From: [REDACTED]
Sent: 16 September 2026 17:40
To: Planning
Cc: Cllr Simon Hore
Subject: Concerns regarding Planning application #3/2026/0634
Attachments: Outflow leet chamber.jpg

Further to our letter "Formal request for clarification and review of amended plans, consultation and residential amenity assessment" regarding planning application #3/2023/0285 The Old Barn, Malt Kiln Lane, Chipping, PR3 2GP and release of conditions application #3/2026/0634 we would like to raise additional concerns as noted below:

DRAWING No. **GA3543-HSLP-01**

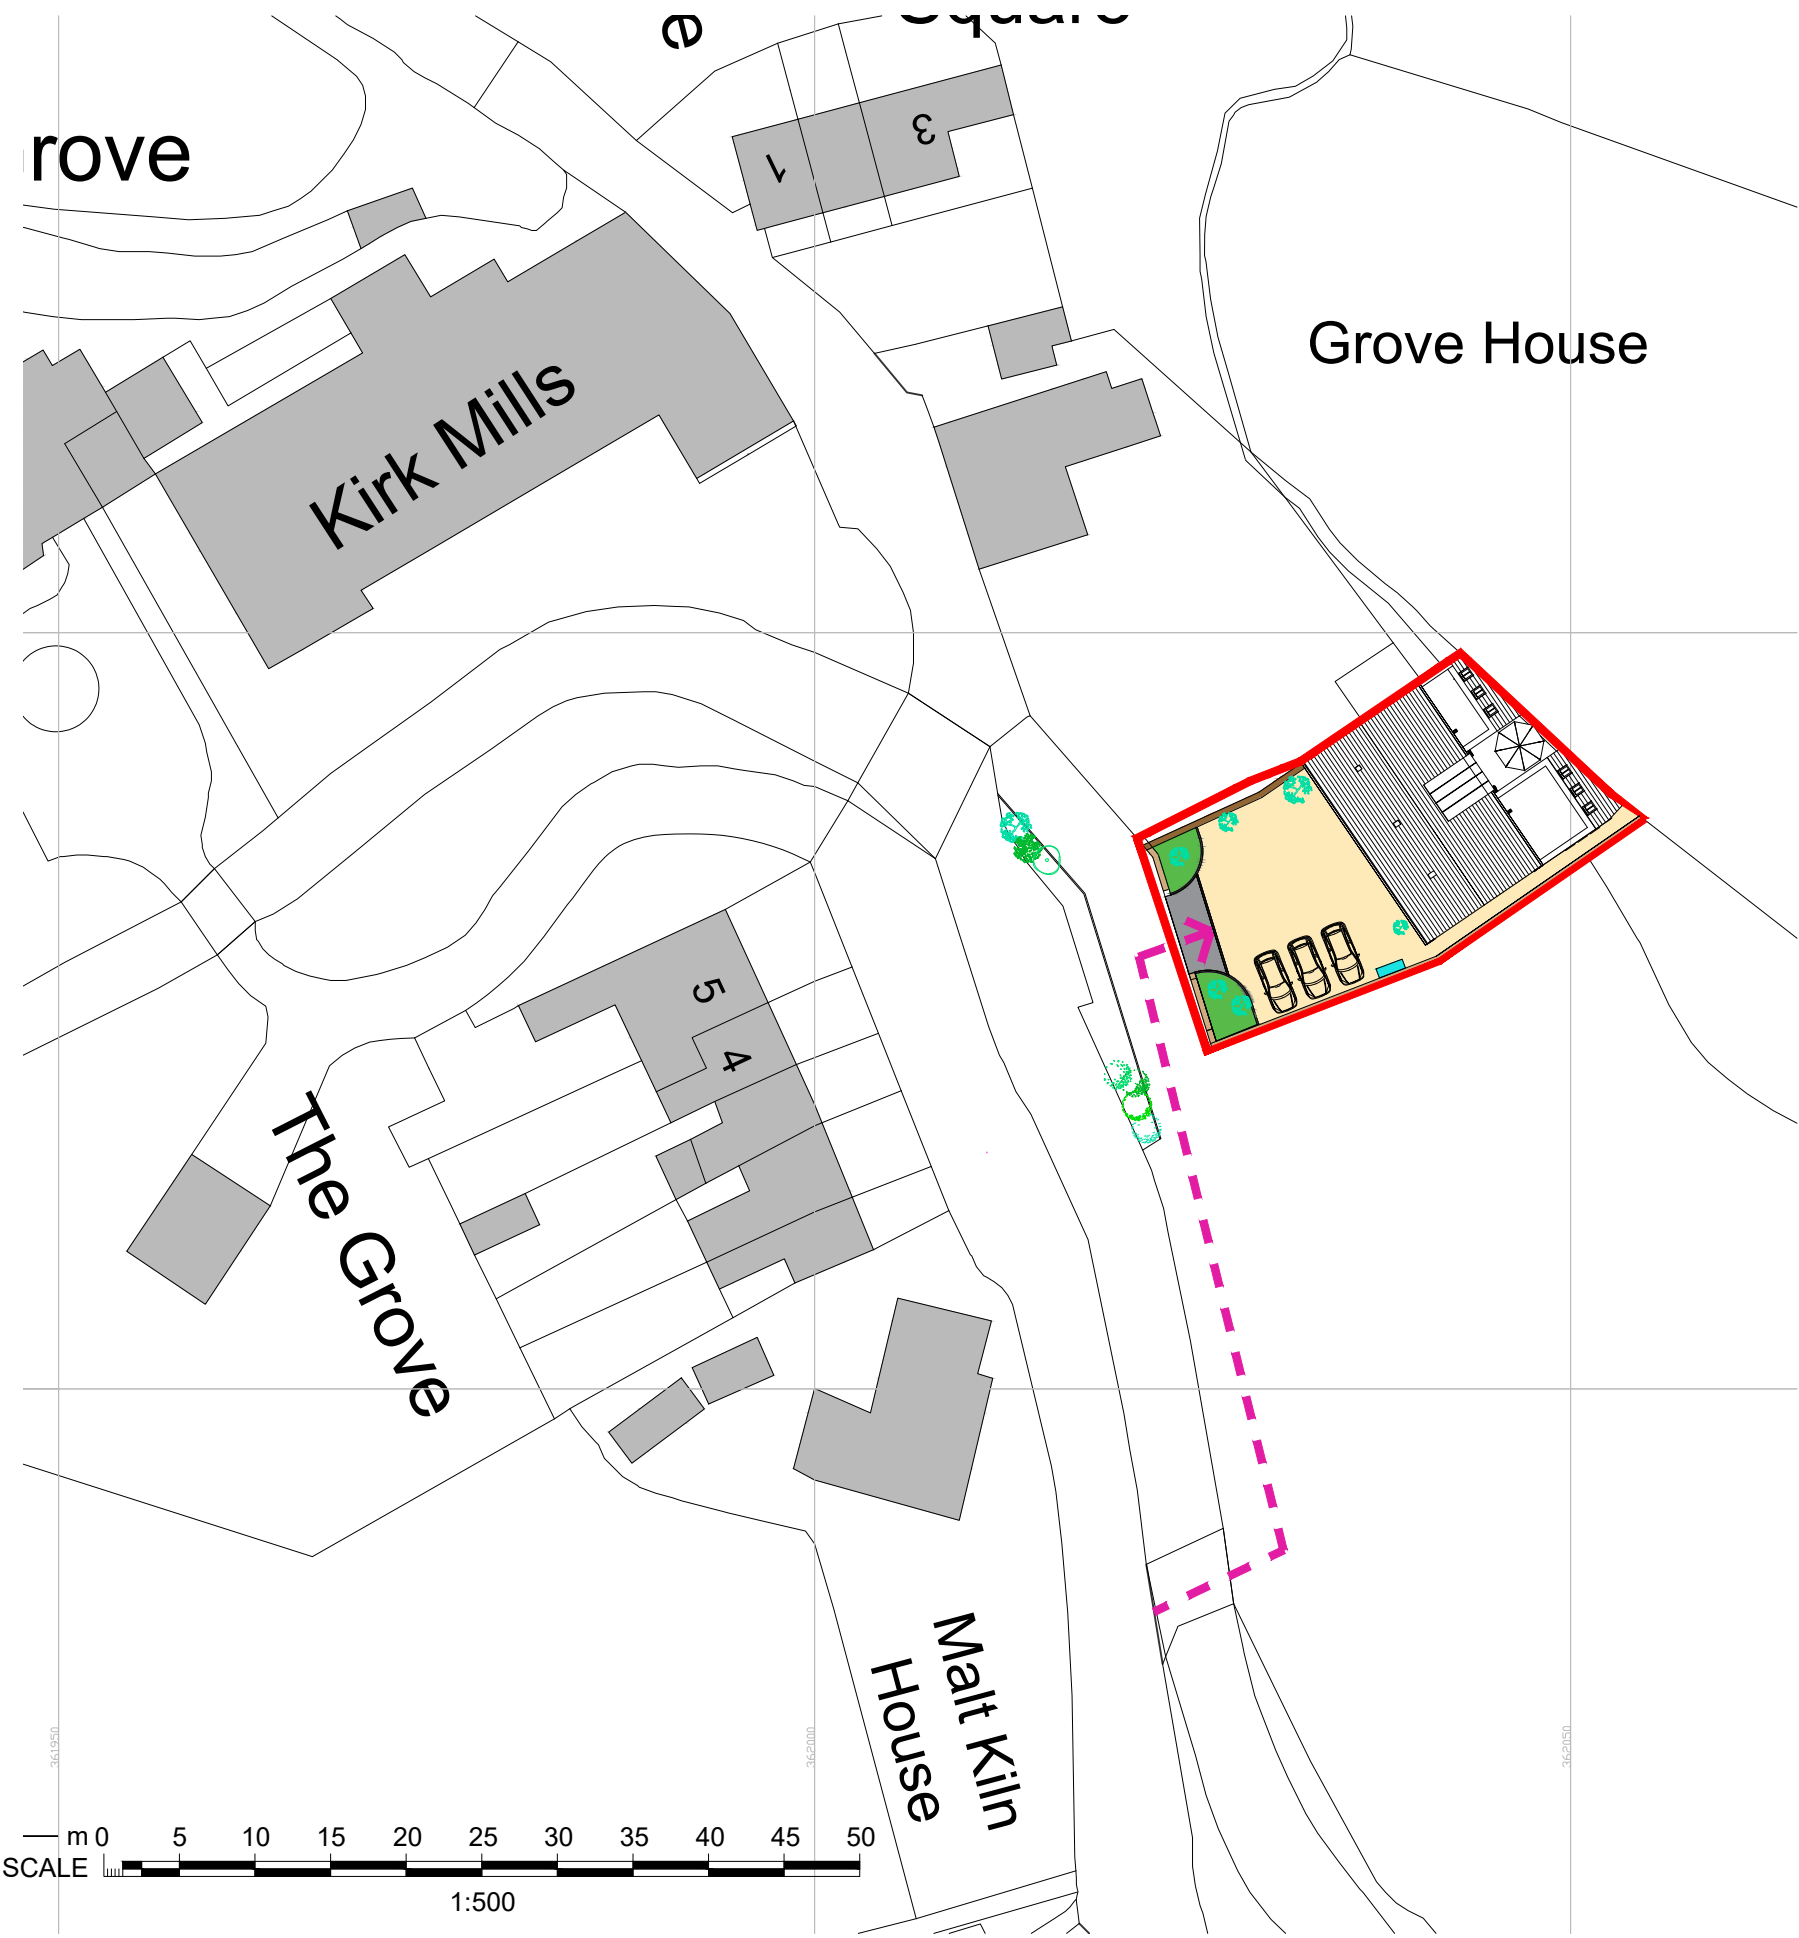
- #3/2026/0634 Proposed Hard and Soft Landscape Plan – Drawing No. GA3543-HSLP-01 Condition 7 on planning permission 3/2023/0285

The proposed hard soft landscaping plan shows a "Proposed stone wall to match existing stone wall"

- #3/2026/0634 Proposed Hard and Soft Landscape Plan – Drawing No. GA3543-HSLP-01 Condition 7 on planning permission 3/2023/0285

Deviating from the original site plan drawing indicating no landscaping

the Hard and Soft Landscaping plan now proposes dug in trees, grass and tarmac to the area at the south west corner of the boundary wall.

No provision has been made for the Manhole Drain cover (located approximately <2 metres south from the south) for its protection from landscaping and required future access for maintenance purposes.

Current landscaping plan shows the manhole cover buried beneath trees and tarmac.

The manhole cover/chamber is a critical piece of historical infrastructure for the Grade 2 listed Kirk Mill main water outflow leet from the water wheel house.

This 4 metre deep chamber (Picture attached) is one of a number which traverse the old factory site linking the Grade 2 listed Kirk Mill Water Wheel outflow down to the lower part of Chipping Brook at the south end of the main site.

Additionally this chamber is the outflow collection chamber of all surface water drainage from the [REDACTED].

Blockage of access or damage to the chamber from landscaping works could result in obstructed flow, back-up and flooding of the surrounding Grade 2 listed properties.

3 underground Georgian clay pipes originating from [REDACTED] enter the chamber from its northern side (see top portion of attached picture) at a depth of only 300mm-400mm from surface level, in the area indicated on the landscape plan as having proposed trees. Obviously, the introduction of trees/tree roots and digging in this area would destroy these delicate pipes and create blockage/flooding issues [REDACTED].

Provision should be made for access and protection of this Critical chamber and manhole cover for the Grade 2 listed properties, additionally protection of underground Georgian pipe work should be taken into account and alternative proposals should be considered rather than buried trees, e.g. potted plants.

DRAWING No. GA3543-EVCP-01
SCALE(S): 1:200 AT A3
DATE: AUG 26'

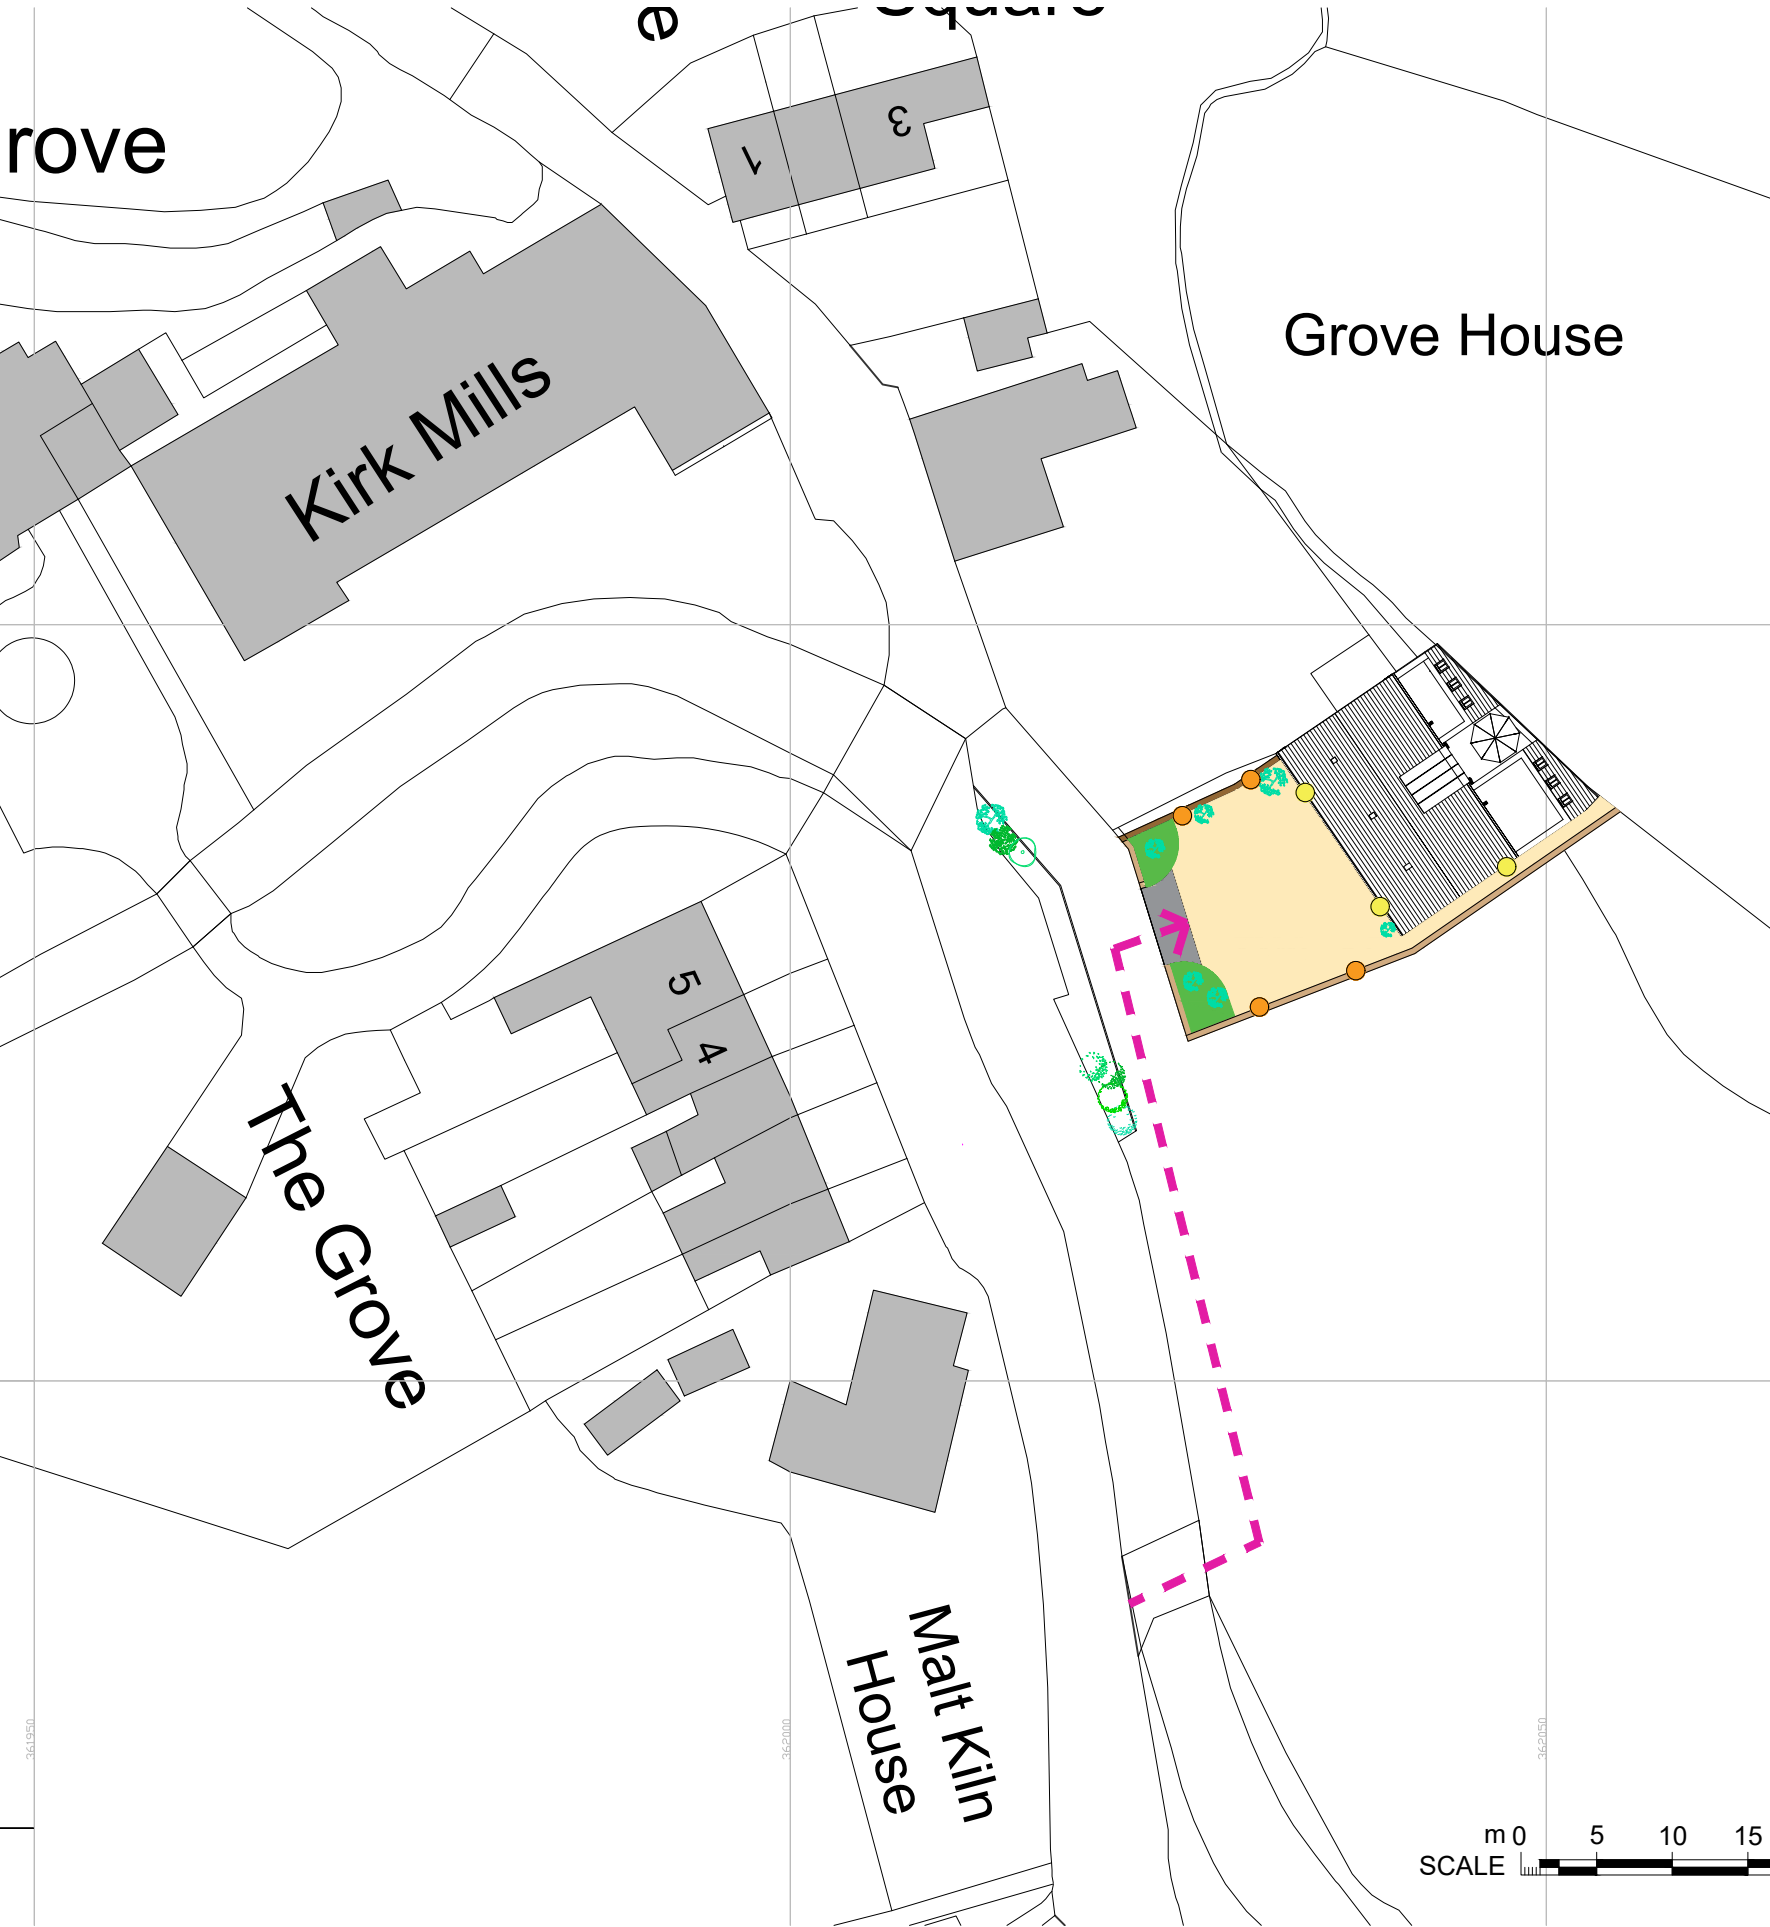
- #3/2026/0634 Proposed External Lighting Plan - Drawing No. GA3543-EVCP-01 Condition 12 on planning permission 3/2023/0285

The proposed external lighting plans shows 2 external boundary wall lights (indicated with orange dots) mounted on to the boundary wall to the Grade 2 listed property of Grove House.

the outer face of which is the property boundary line between properties.
